Planning Application Number:	S6/2015/1342/PP
Site Address:	Land to the north east of King George V Playing Fields Northaw Road East Cuffley Hertfordshire EN6 4RD
Description:	Outline planning application for residential development of up to 121 dwellings, associated infrastructure and a change of use from agricultural land to an extension of the King George V playing field. All matters reserved except for new vehicular access to serve the site, the provision of surface water discharge points and the levels of development platforms

Comments:

DRAWING NUMBER: **141386/A/35** REVISION: **D**

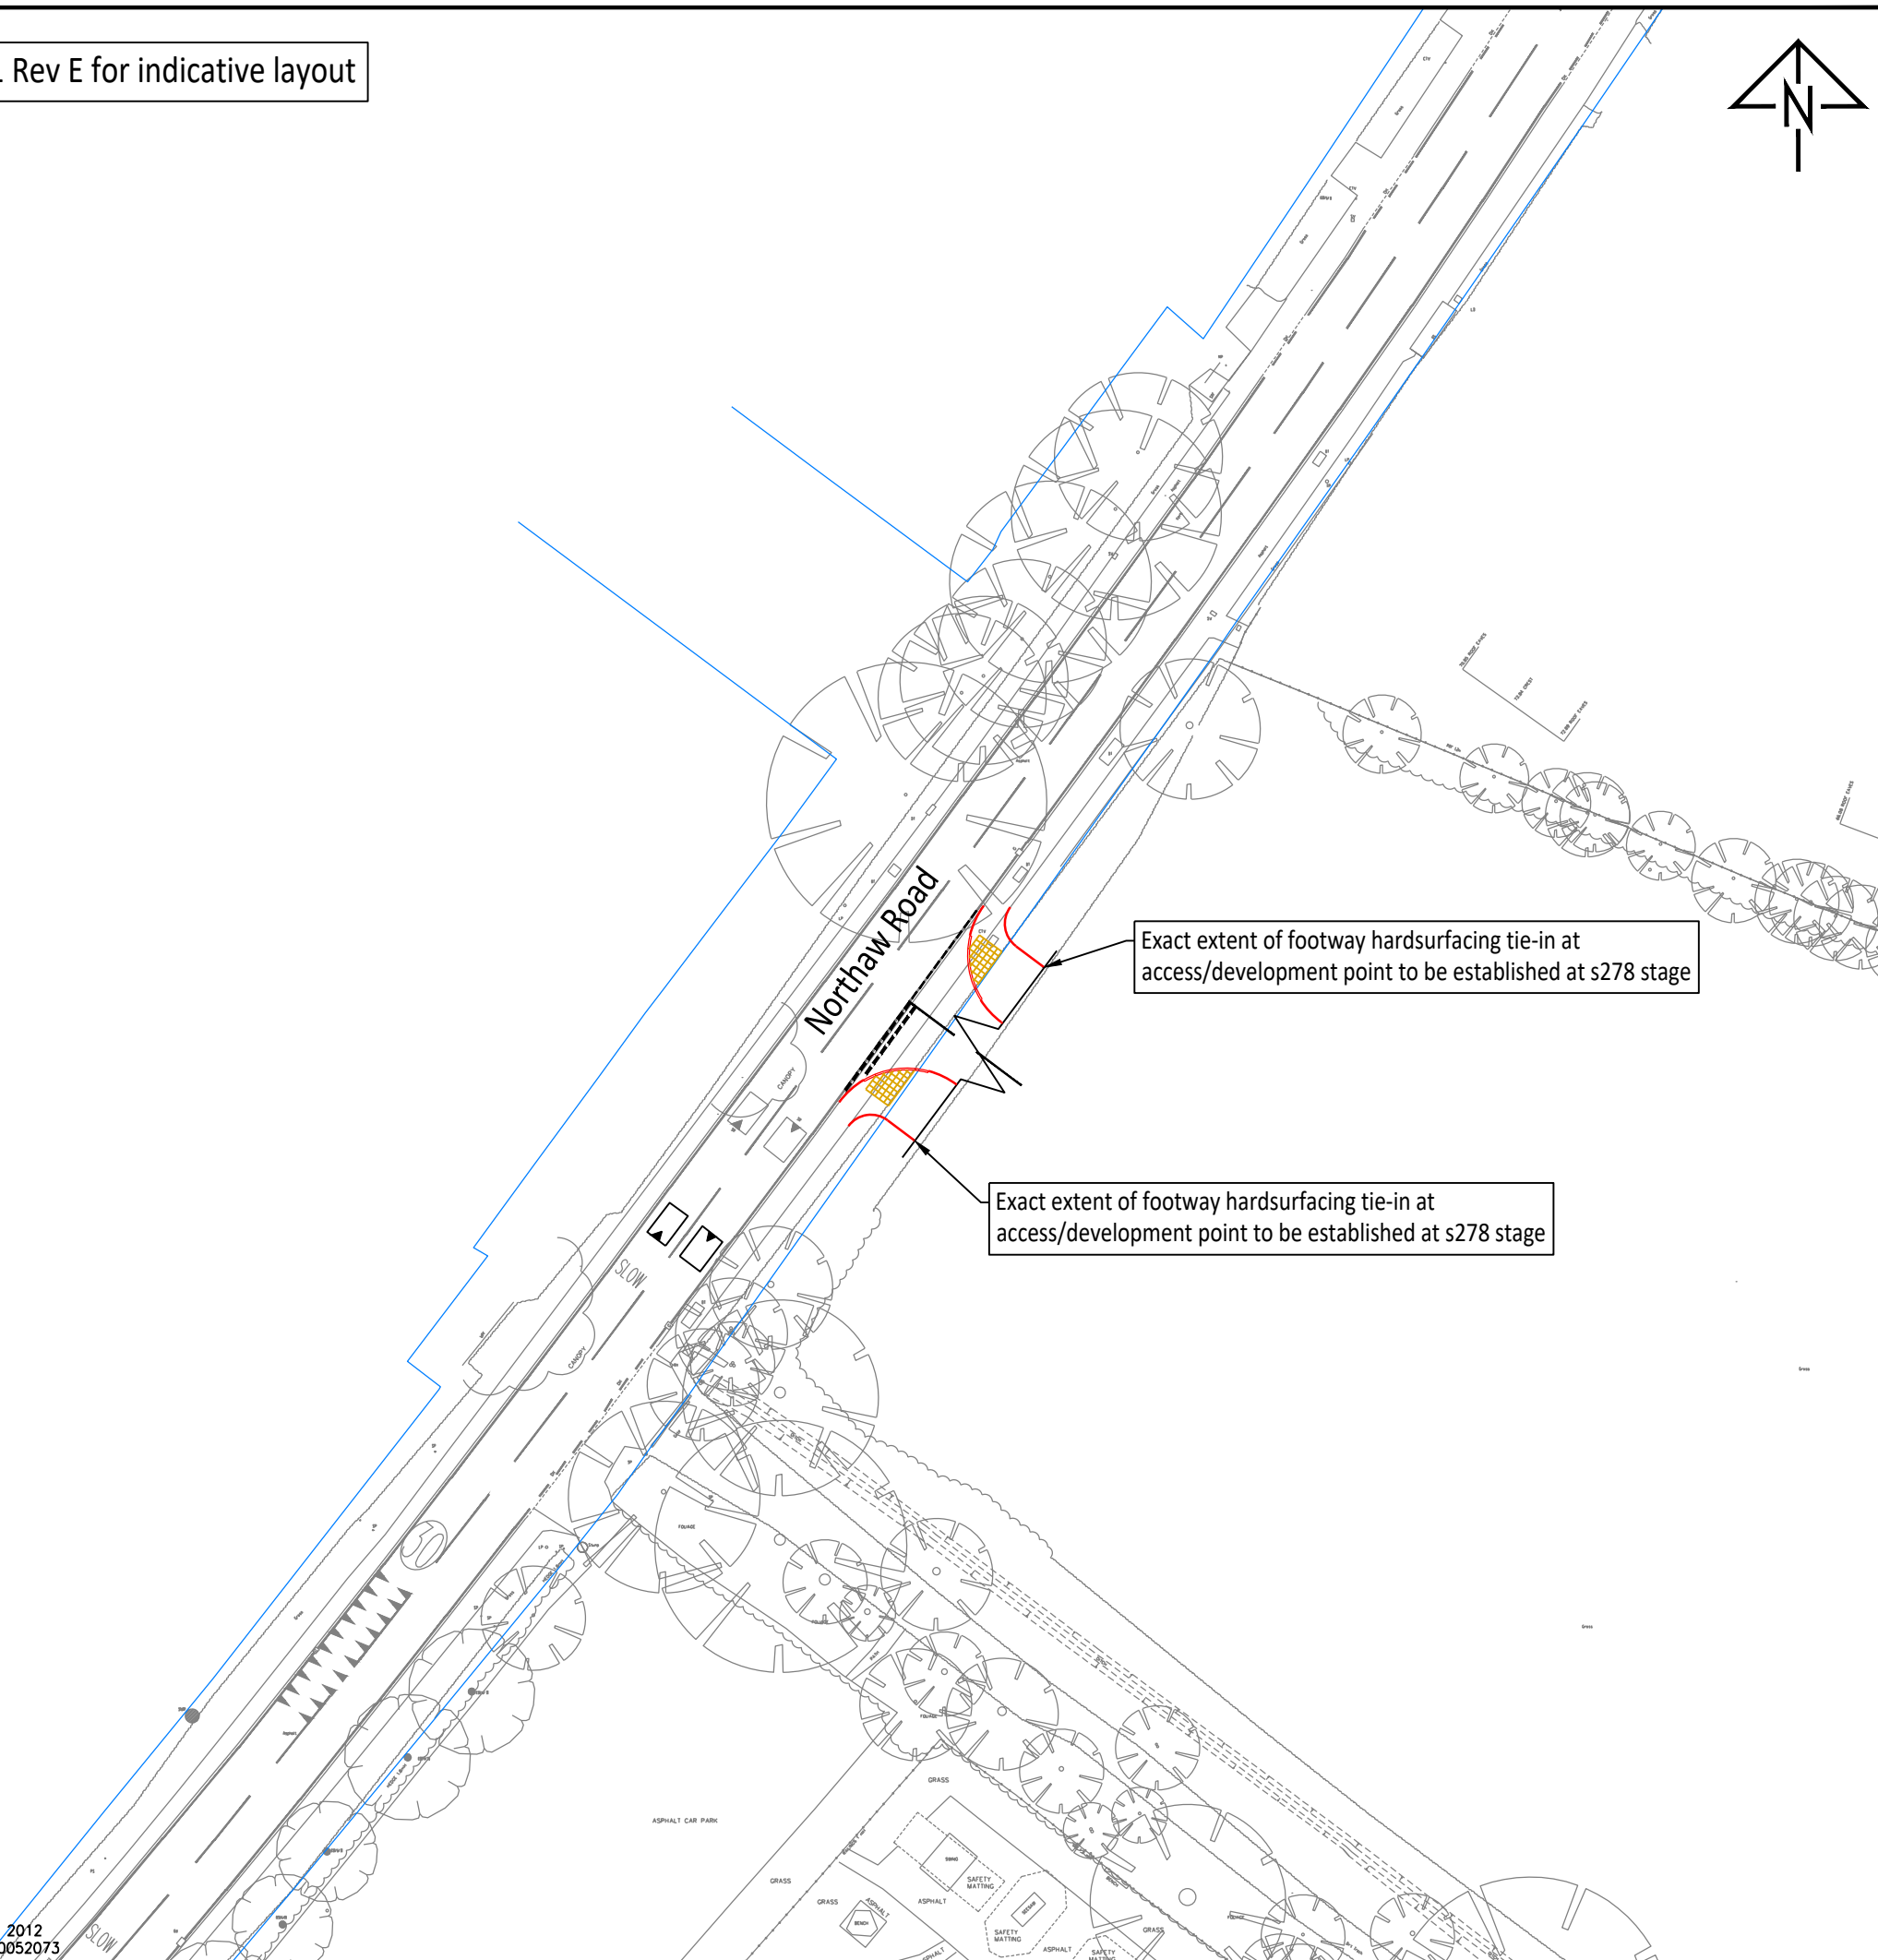
The proposed development proposes a single point of vehicular access, by way of priority junction onto Northaw Road East. (Drawing 141386/A/35 Rev A). The applicant has also provided drawings showing an example of Village Gateway Improvement which will be incorporated into the access design.

The access shall represent 5.5m wide carriageway width, appropriate to Roads in Herts table 4.1.1.1 and sufficient to represent a Major Access. 5.5m is sufficient in width to enable two way vehicle flow without interference. Access is provided with verge and footway both sides, footway width shown to 2m, again in accordance with RiH. Bellmouth radii appears to be 5.5m, and swept path plots are provided that demonstrate the access accommodates fire / refuse vehicles.

4. Before first occupation of the development hereby permitted, site access as shown in principle on drawing 131386/A/35 Rev A and incorporating village gateway improvement on drawing 141386/A/34 shall be completed and constructed to the satisfaction of the Local Planning Authority in consultation with the Highway Authority.
